Urban Design Review Panel Report

500 Coventry Road, Ottawa

December 12, 2025

**RE: Urban Design Review Panel Report
Site Plan Control Application
500 Coventry Road, Ottawa**

DRAWING NO. SPA005A	REV. 3
------------------------	-----------

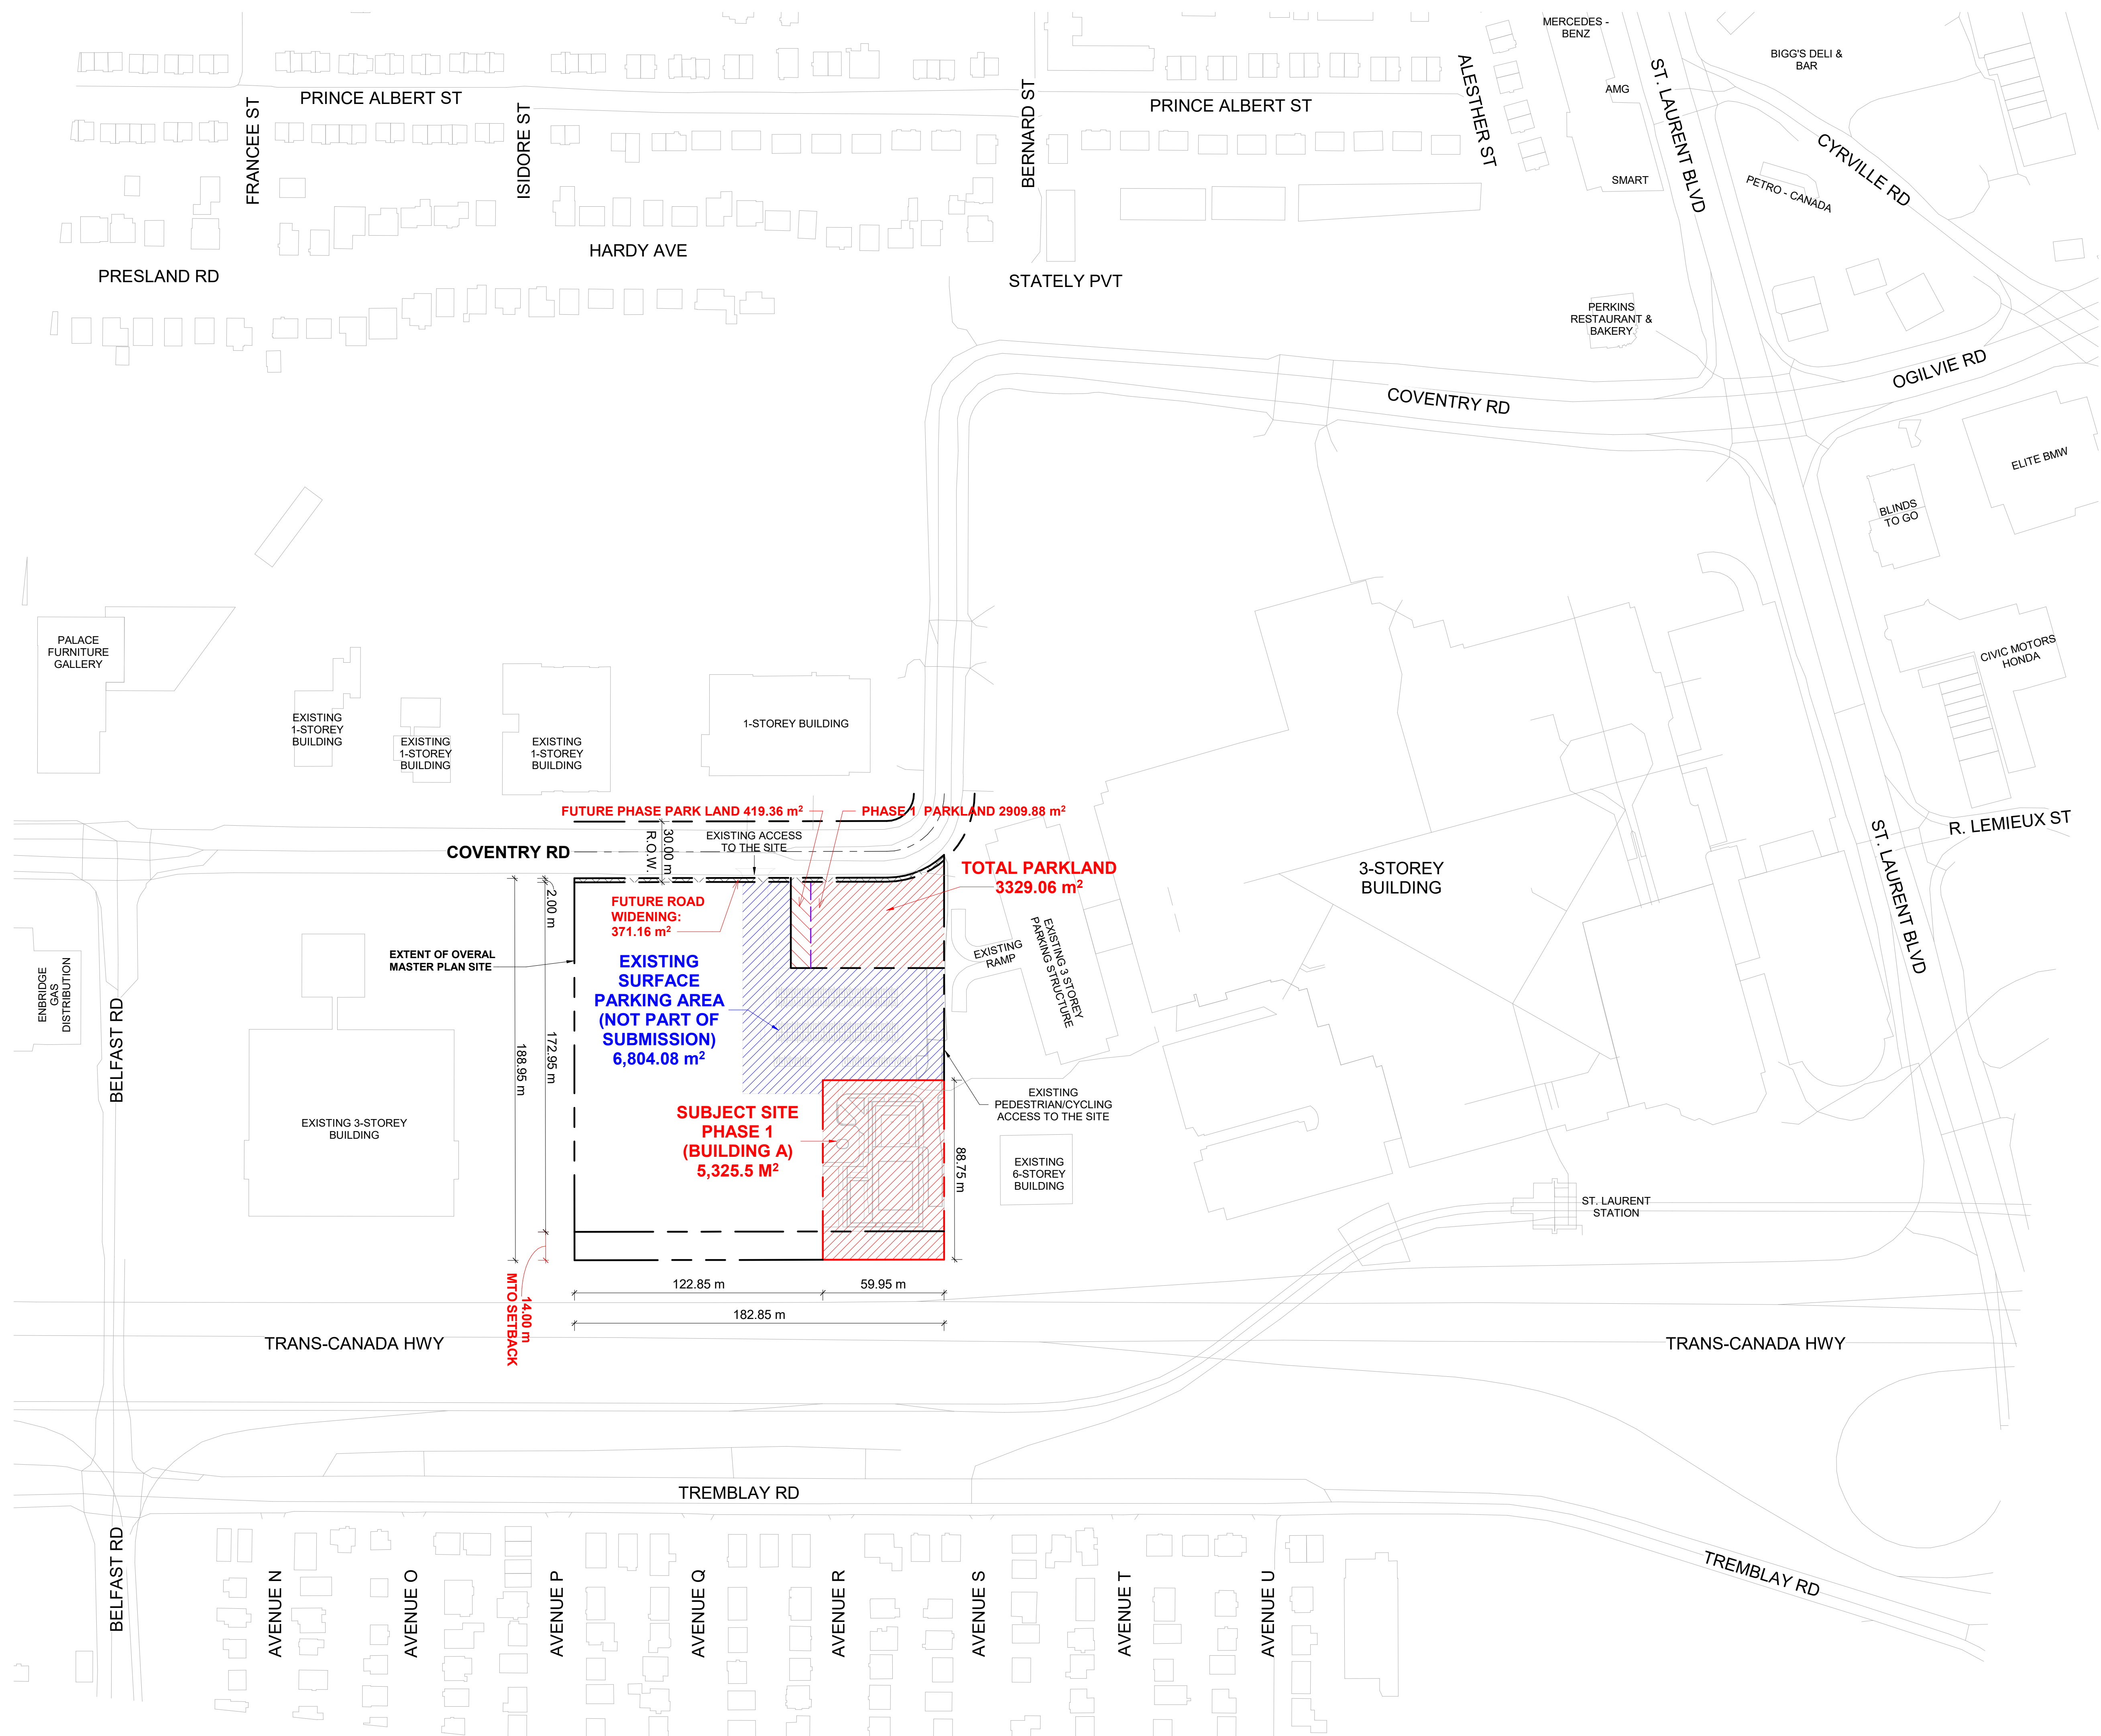
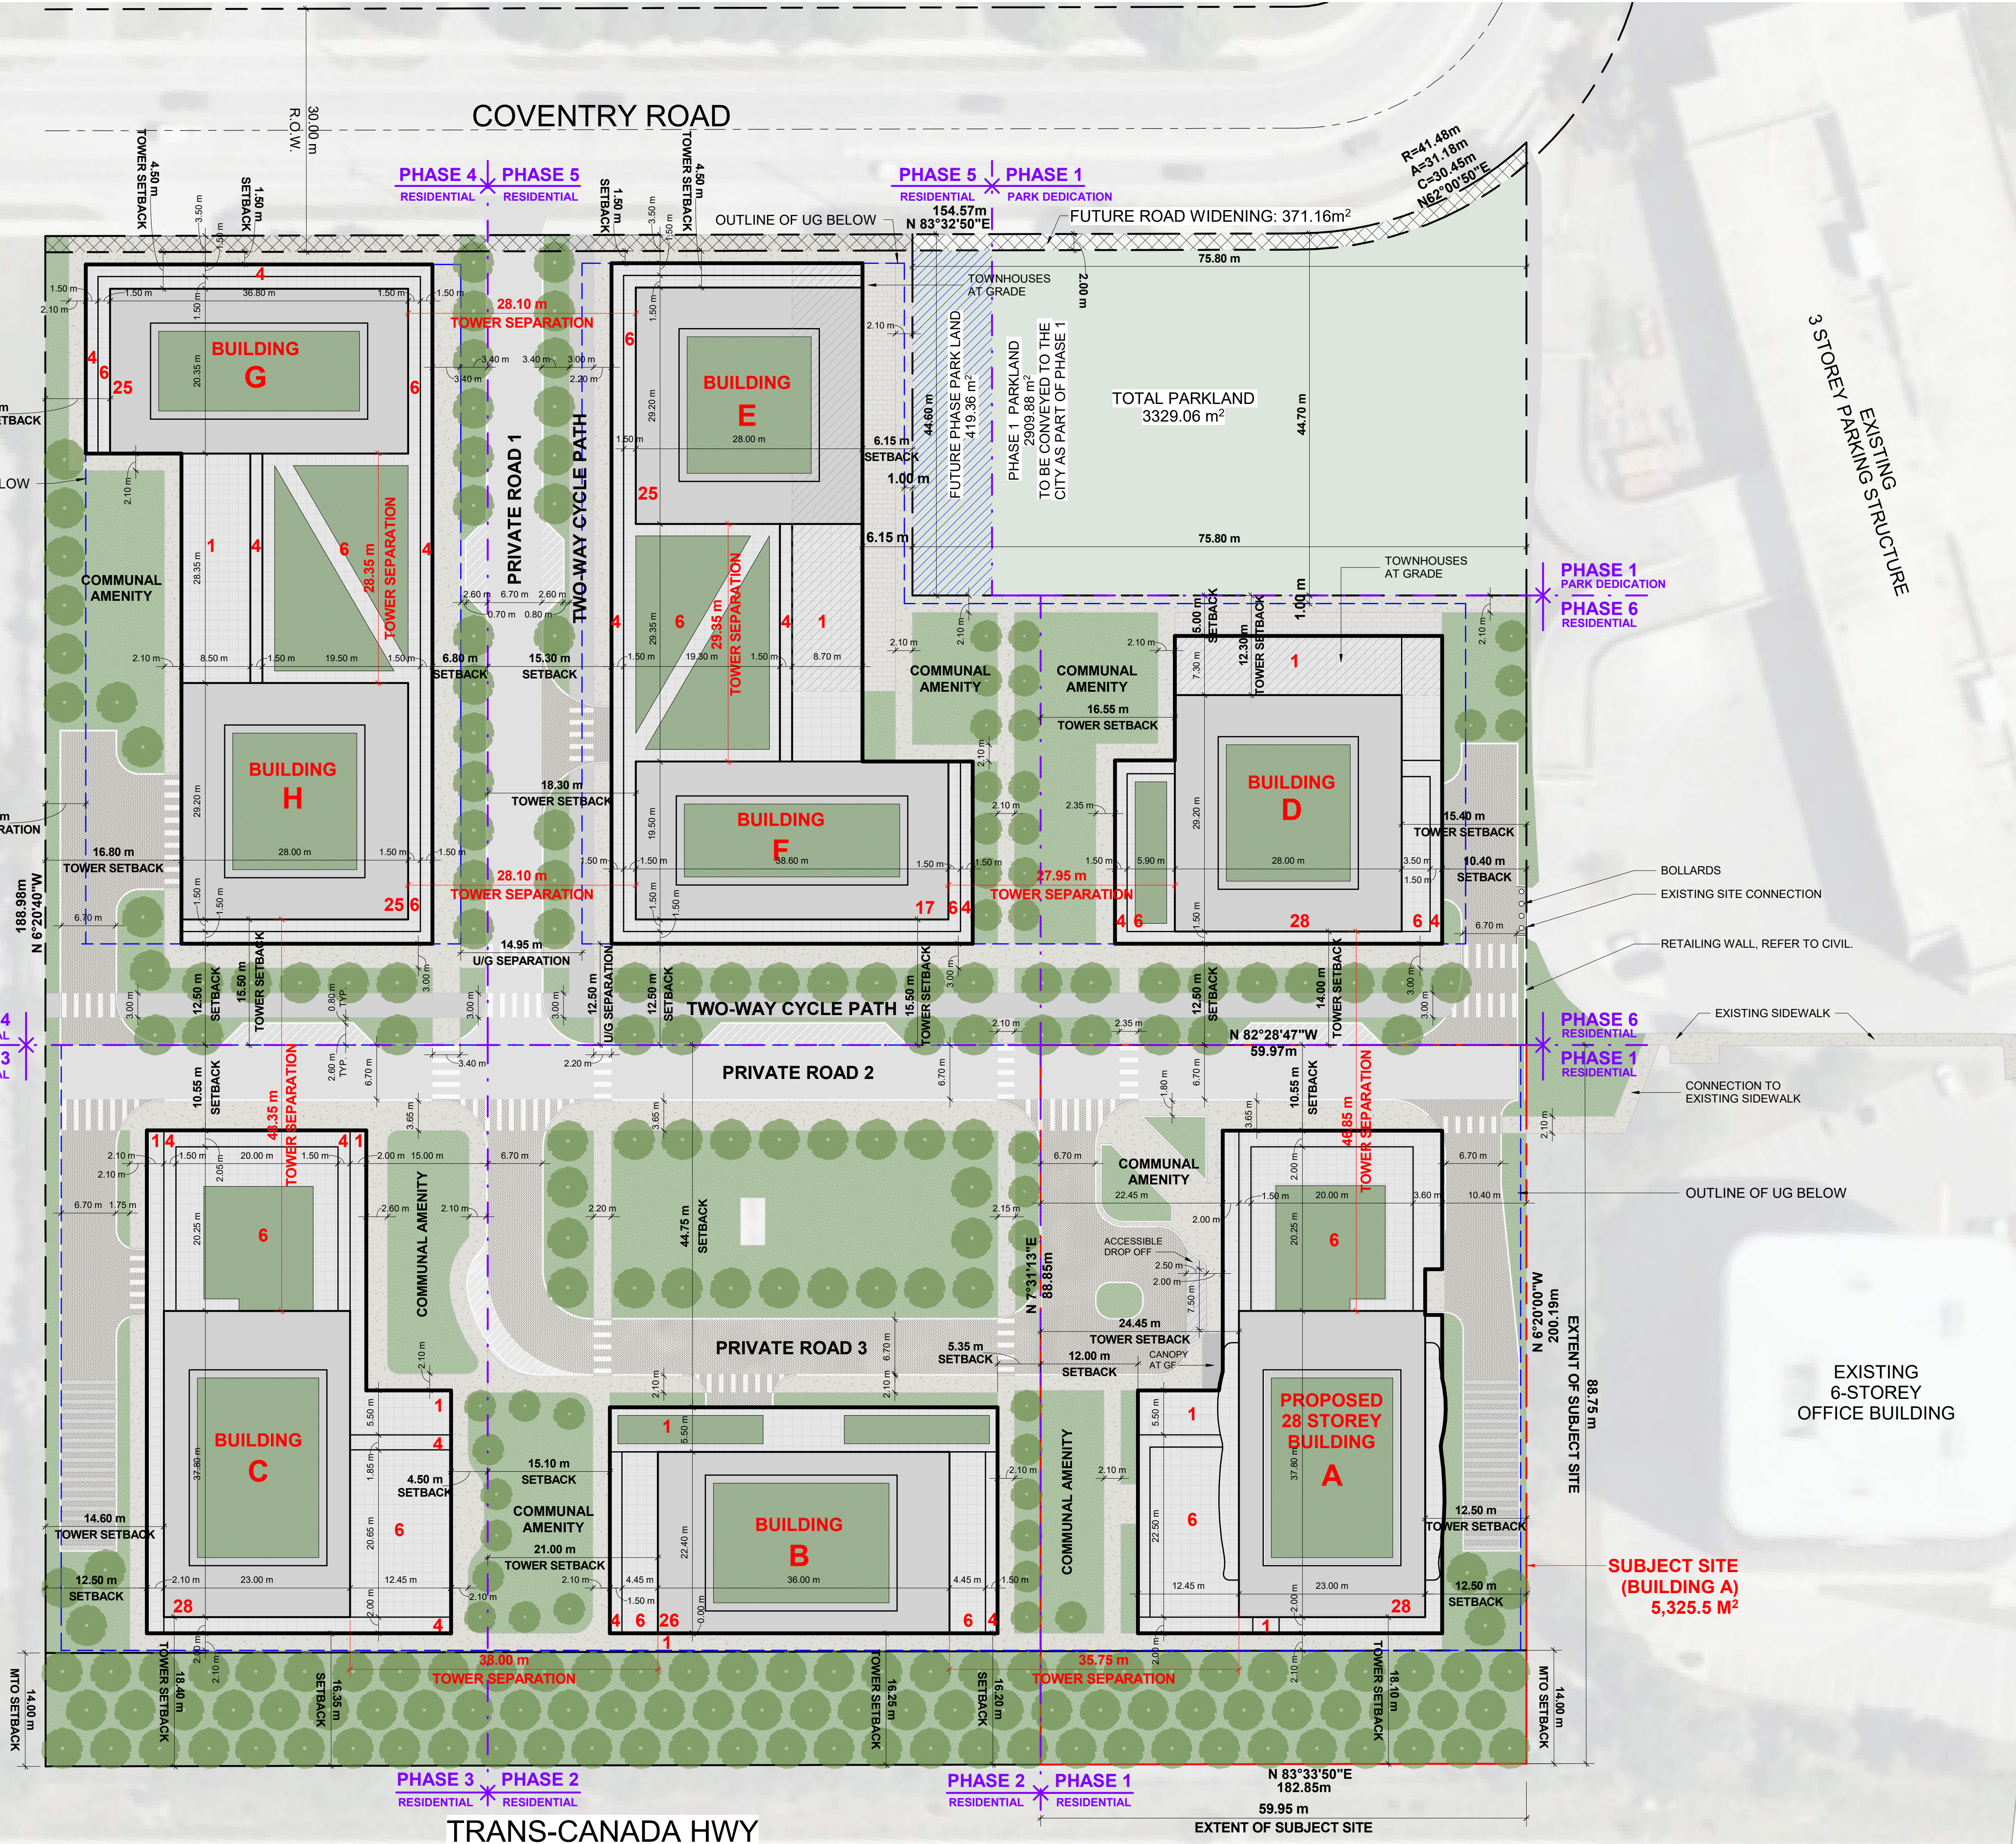
2. The Panel strongly recommends more thought be given to creating a pedestrian-first built environment and layering to the Phase 1 Master Plan presented (p.26), as it currently appears overly vehicle oriented.

3. The Panel recommends further exploring ways in which the vehicle-oriented roads can be evolved into pedestrian-oriented streets, with consideration of how these streets will be activated/animated with pedestrians.

6. The Panel recommends the dedicated parkland be lined with grade-related units to further activate the park space, and that vehicular uses such as loading/drop-offs be relocated away from the park.

7. The Panel recommends further exploring how best to terminate long views with architectural interest. Consider opportunities for communal pavilion spaces and/or sculptural elements to help anchor views and bring people in the community together.

8. The Panel has concerns about the underground parking ramps being exposed and highly recommends tucking the parking ramps within the building envelope.

13. The Panel appreciates that this master planned area, and Coventry Road more generally, presents a challenging landscape to establish a new high-rise community.
 - The Panel has strong concerns with how this master planned community will establish a robust and pedestrian-first public realm environment, given its existing light industrial and car-oriented commercial character.

15. The Panel recommends adding more linkages through the site to the dedicated parkland on the corner.
 - For example, connect pedestrian green space between Building F and Building D to create amenity spaces for pedestrians instead of multiple loading and drop-off areas.
 - Consider connecting the communal amenity to other pedestrian areas, rather than the existing 'island' effect presented by surrounding vehicular circulation.
 - The Panel recommends dialing back the vehicular components of the master plan in return for a more pedestrian-first public realm environment. Pedestrians ought to be the highest order of mobility in the master plan.

16. The Panel recommends exploring designs for a pedestrian pathway that wraps around the site on all sides and connects the amenity spaces to the outdoors.

23. The Panel appreciates the long axial views provided in the Master Plan and recommends further exploring the role of long views into and through the Master Planned site.

Response: Master plan design has been revised to be more pedestrian oriented with less paved road. Refer to sheet SPA005A.

Response: Master plan design has been revised to be more pedestrian oriented with less paved road. Refer to sheet SPA005A.

Response: Townhouses at grade have been provided and loading has been relocated. Refer to sheet SPA005A.

Response: Communal amenity areas have been proposed at the terminal of each long views, with the potential to add landscape and public features. Refer to sheet SPA005A.

Response: Majority of ramps have been internalized. The addition of a parking ramp structure has been designed to partially cover the ramp, tying it into the design of the building. Refer to sheet SPA005A.

Response: Master plan design has been revised to be more pedestrian oriented with less paved road. Refer to sheet SPA005A.

Response: Pedestrian green space provided between building D and F, amenity areas are more interconnected, and more focus on the pedestrian was introduced to the updated master plan design. Refer to sheet SPA005A.

Response: Pedestrian pathways provided on the interior of the site but not the perimeter to bring the focus back on the community inside the master plan. Refer to sheet SPA005A.

Response: Communal amenity areas have been proposed at the terminal of each long views, with the potential to add landscape and public features. Refer to sheet SPA005A.
